Consultation Response from KC, Strategic Housing
2023/93704 land northwest of, Urban Terrace, Denby Lane, Grange Moor, Huddersfield, WF4 4EB
Erection of 12 dwellings and associated works
Date Responded: 10/10/2024 Responding Officer: KC, CH Responding Ref: SH/23/93704

APPENDIX A: Proposed Development Layout

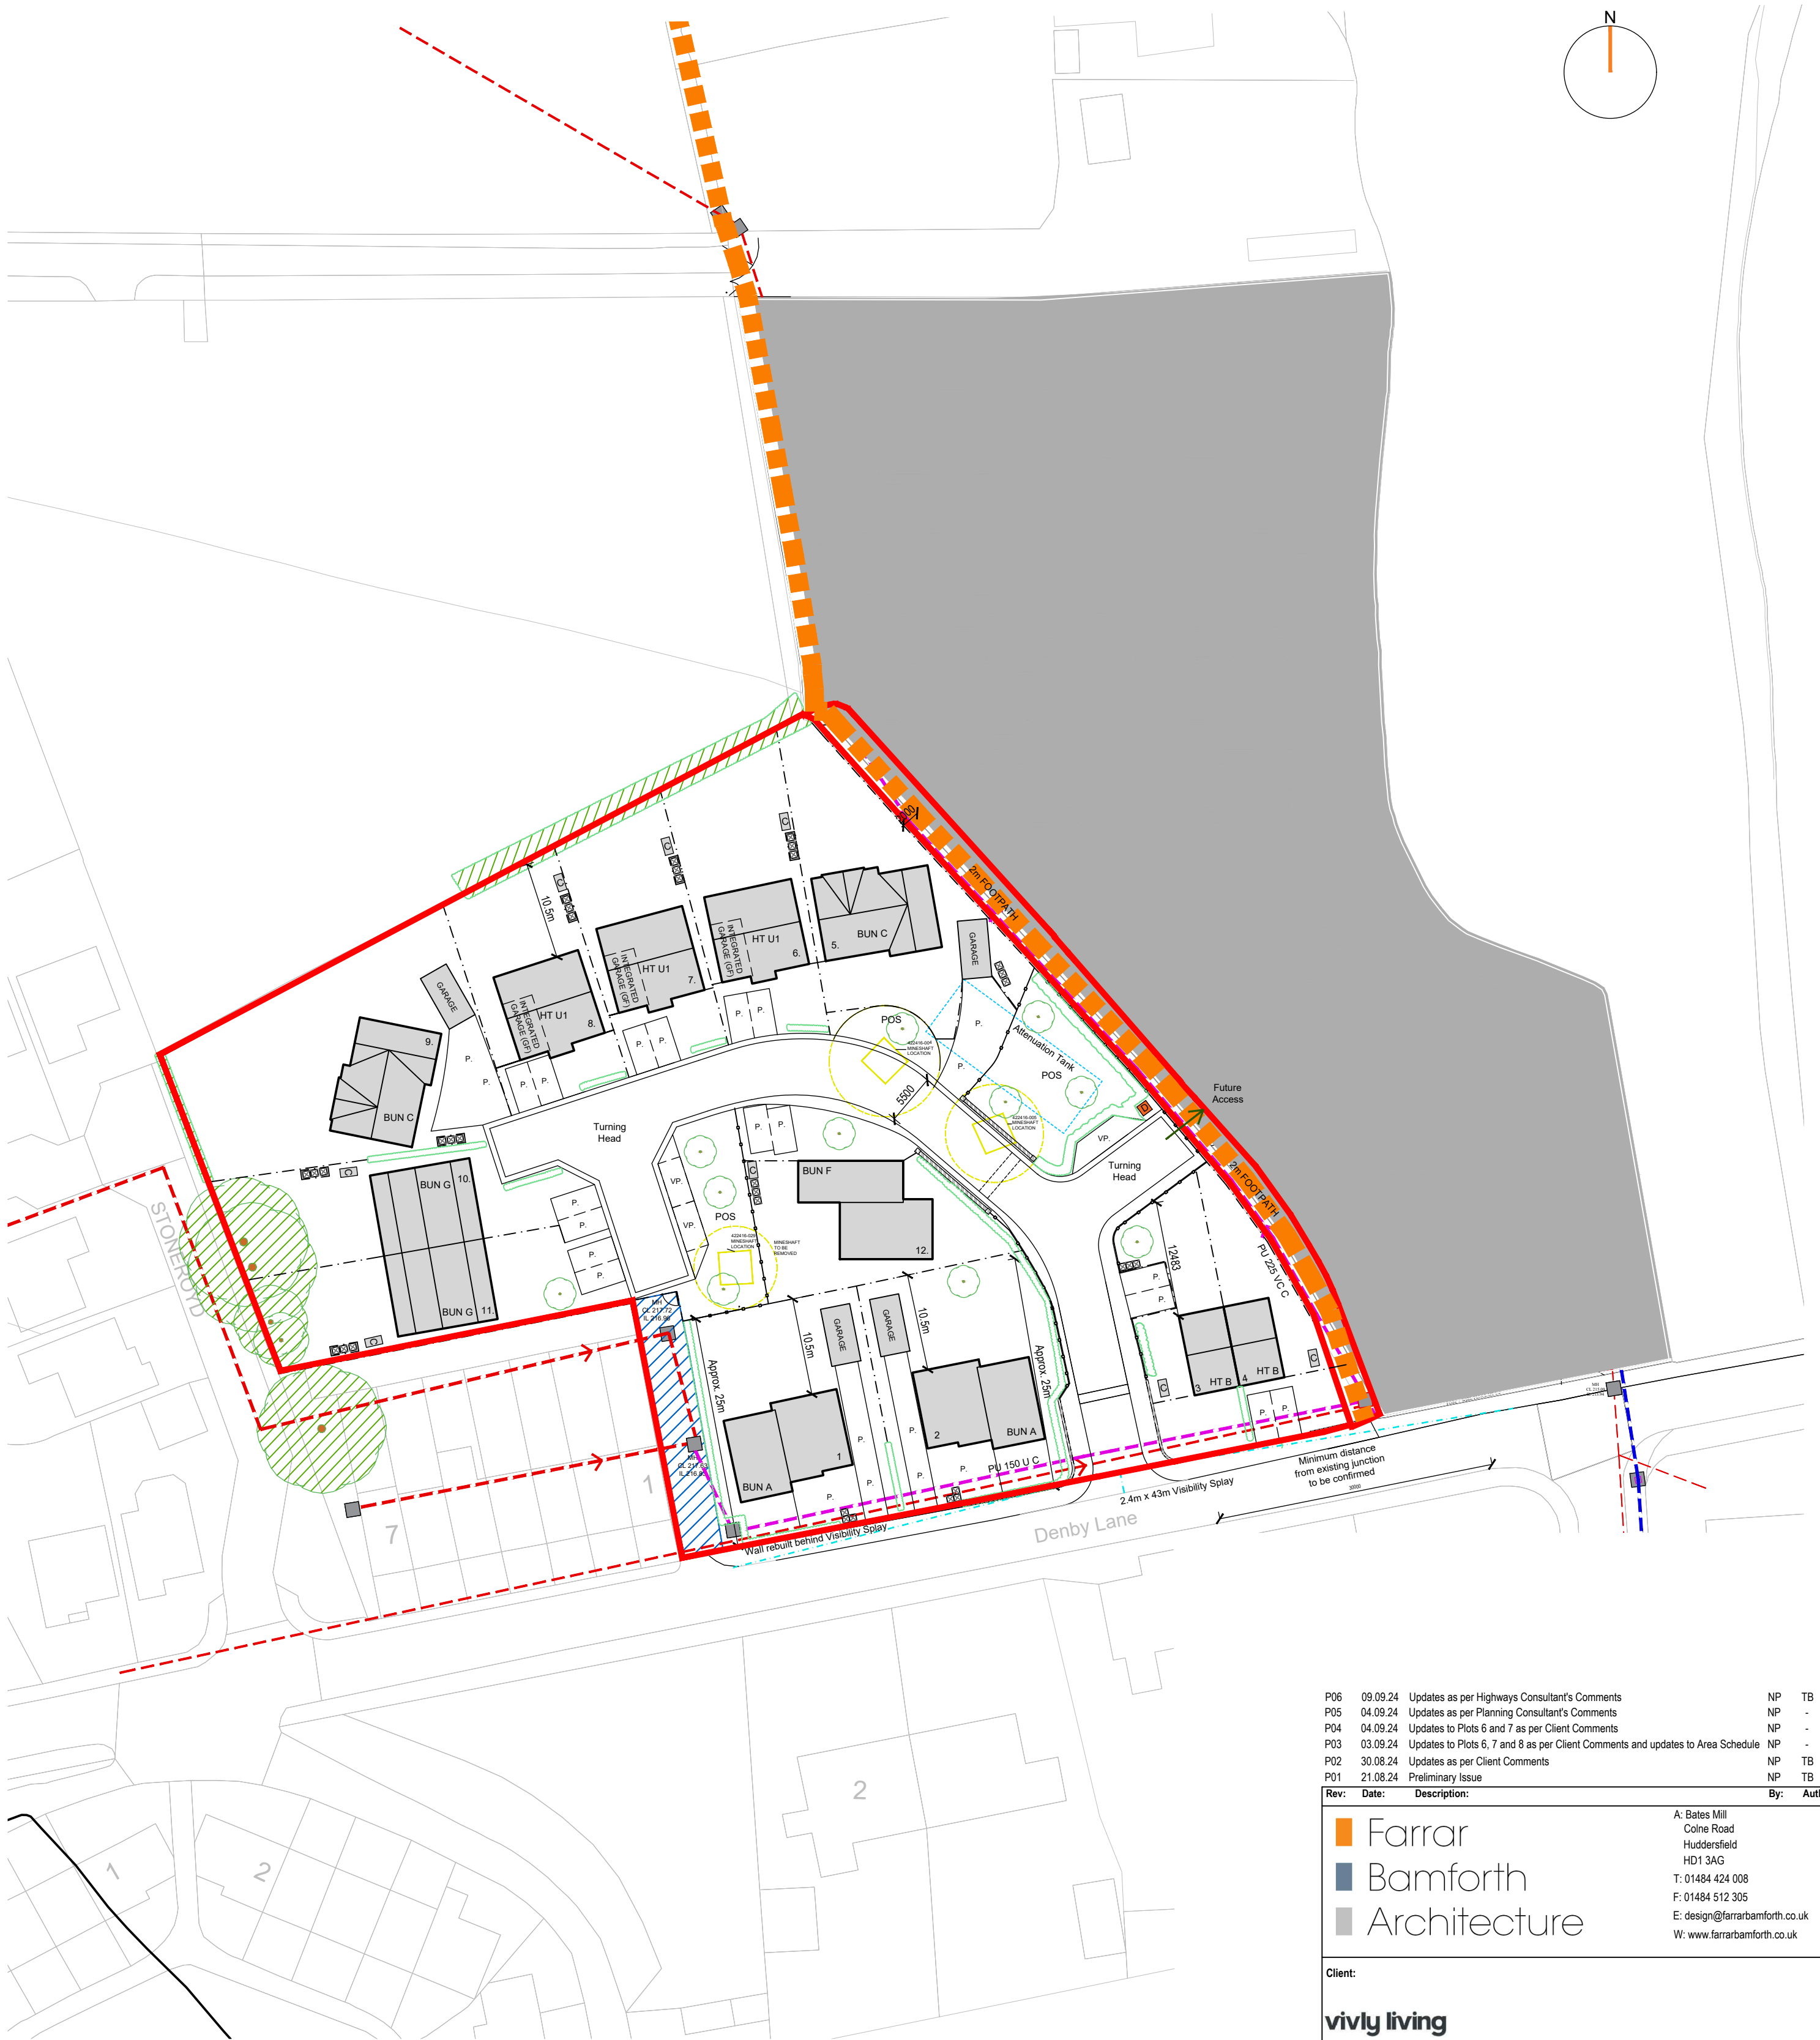
Type: The applicant proposes the following:

Market Housing	Affordable Social Rent or	Affordable Intermediate
1 and 2 bed	3 (30%)	0	2 (100%)
3 bed	4 (40%)	0	0
4+ bed	3 (30%)	0	0

The SPD shows that there is a high need for 1 and 2 bed properties in the area. The proposed 4 bed properties provides more than the need indicated in the SPD. Strategic Housing request that the housing mix is amended to comply with the Housing Mix table in the SPD.

As detailed previously, with regards to the affordable housing for this development, 1 home should be affordable or social rent and 1 should be an intermediate dwelling. We would ask for the proposal to be amended to provide 1 Affordable or Social Rent dwelling.
